28.10.2024

Our Ref: SI/01/OVF

Application 3/2024/0766: Old Vicarage Farm Talbot Bridge Road Bashall Eaves BB7 3DB

Proposed barn conversion

Drawing Title  
**PROPOSED FLOOR PLANS ELEVATIONS AND SECTION**

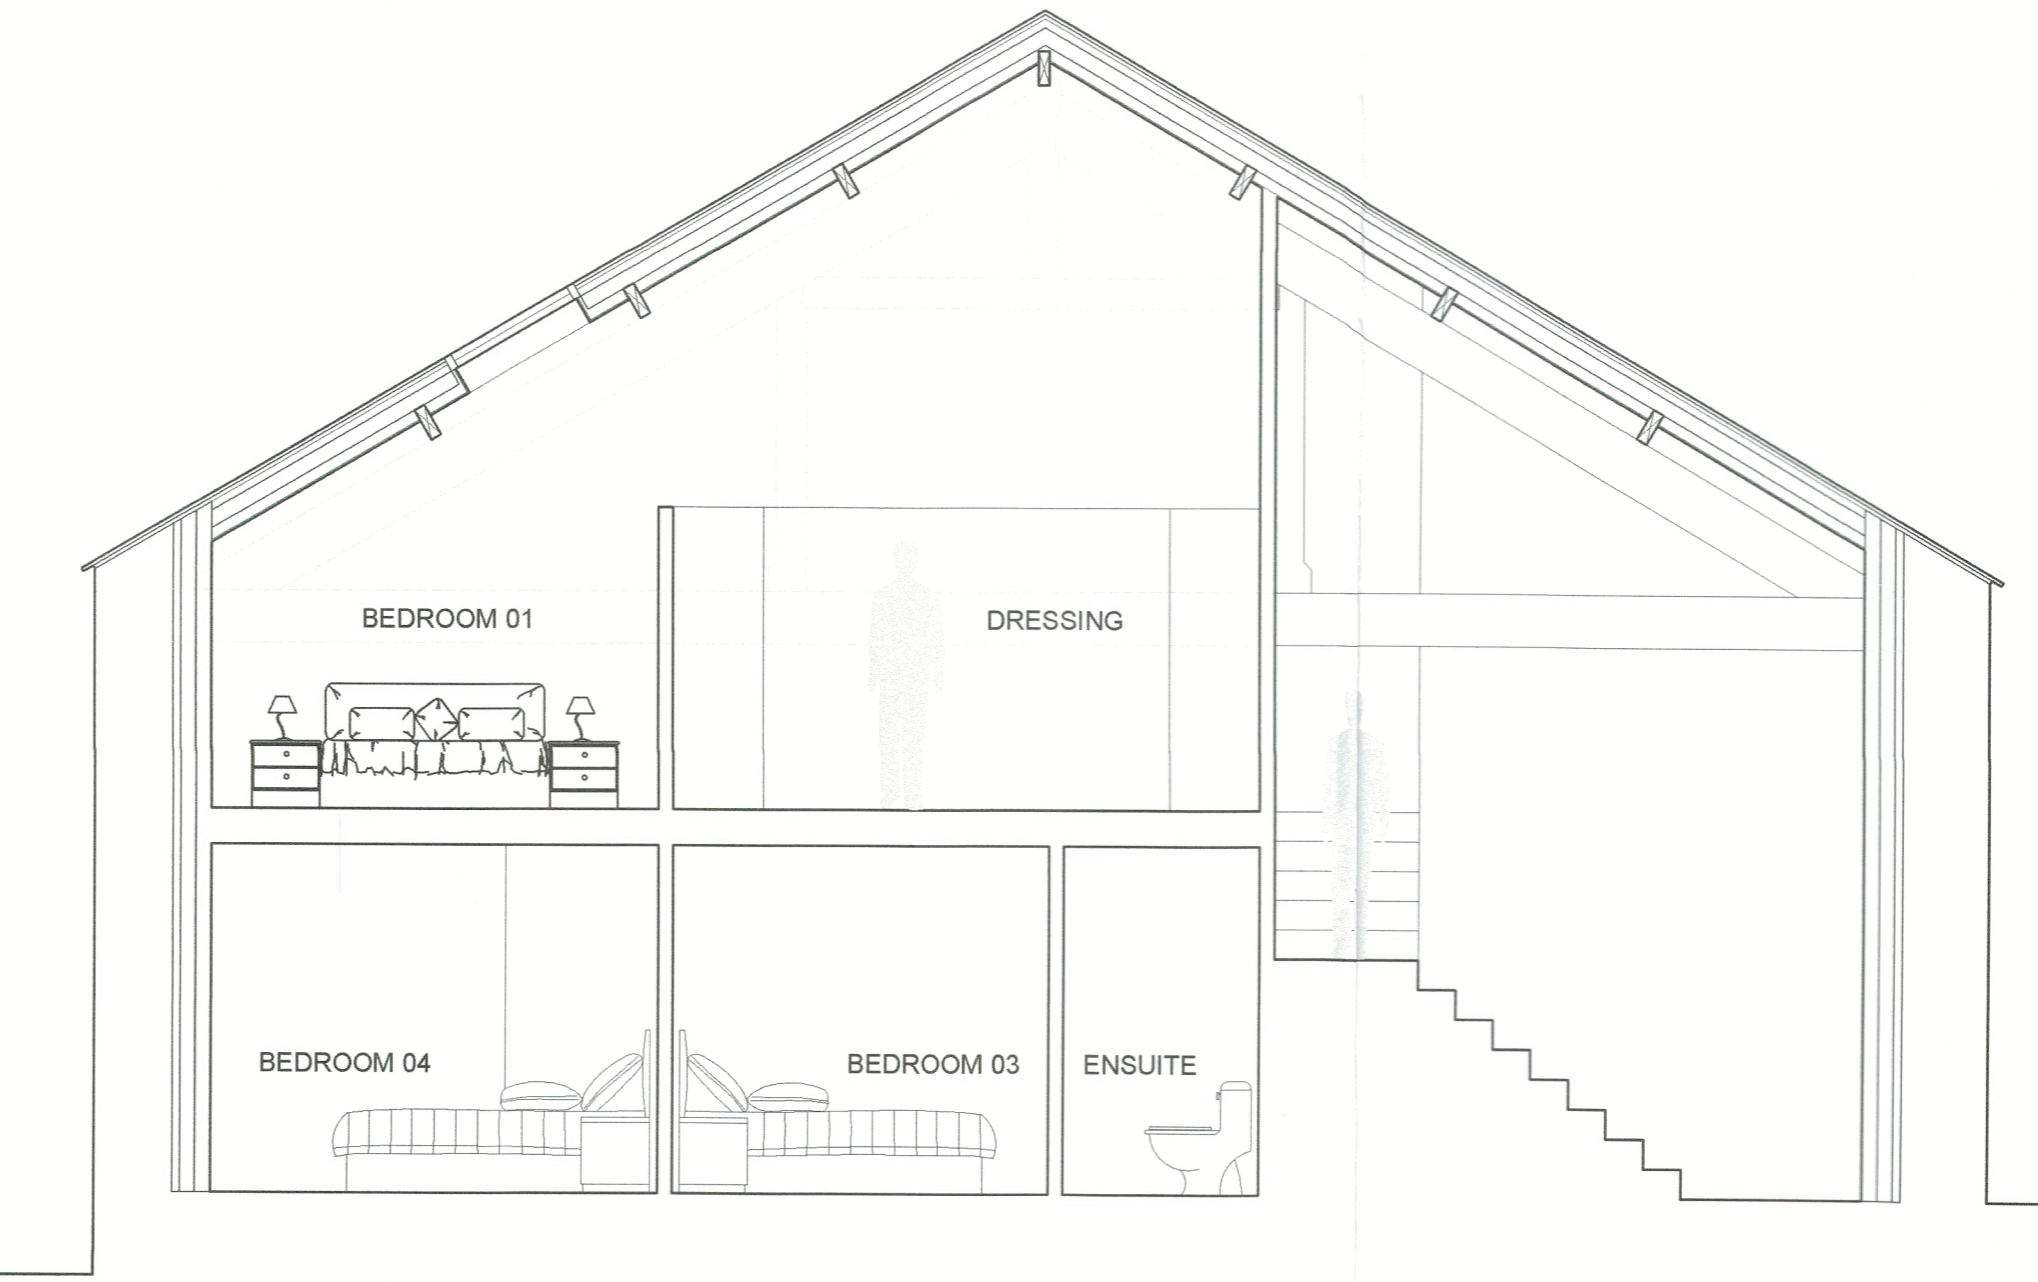
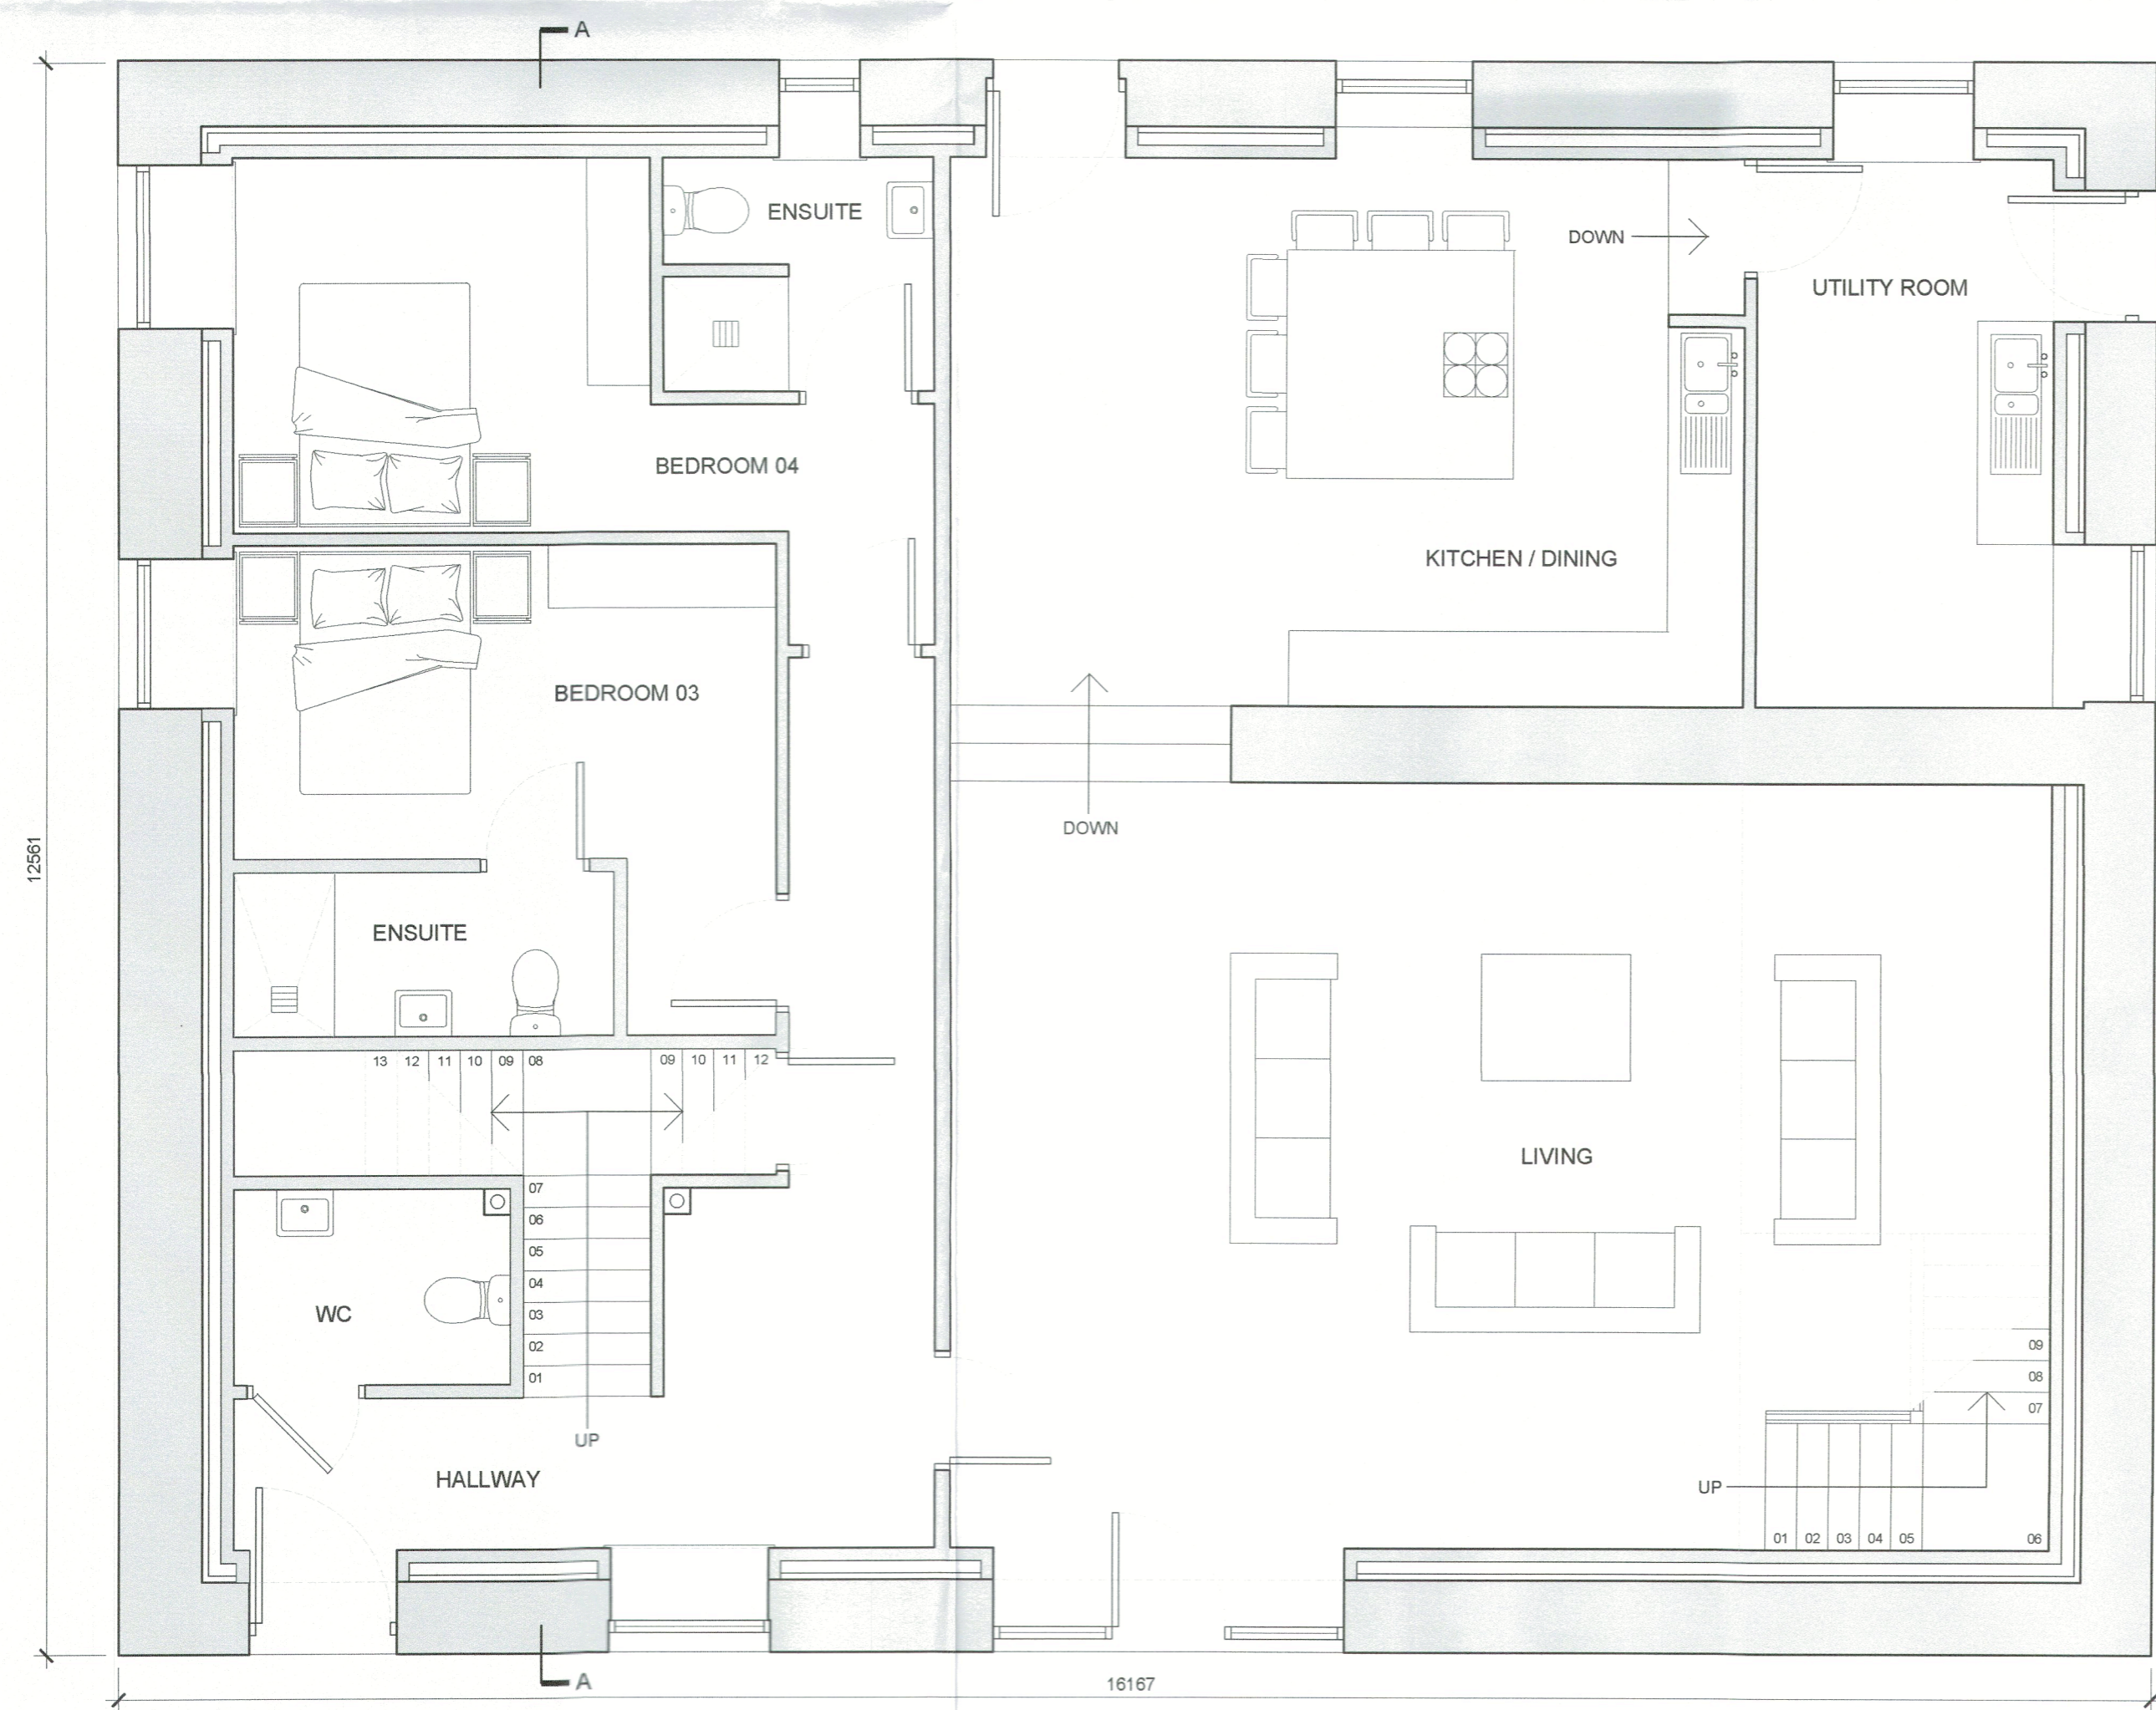
- The mitigation proposed is in the converted building, however from the architects drawings I do not see anywhere that a dedicated void can be allocated to a barn owls as the ceiling is vaulted and velux windows incorporated
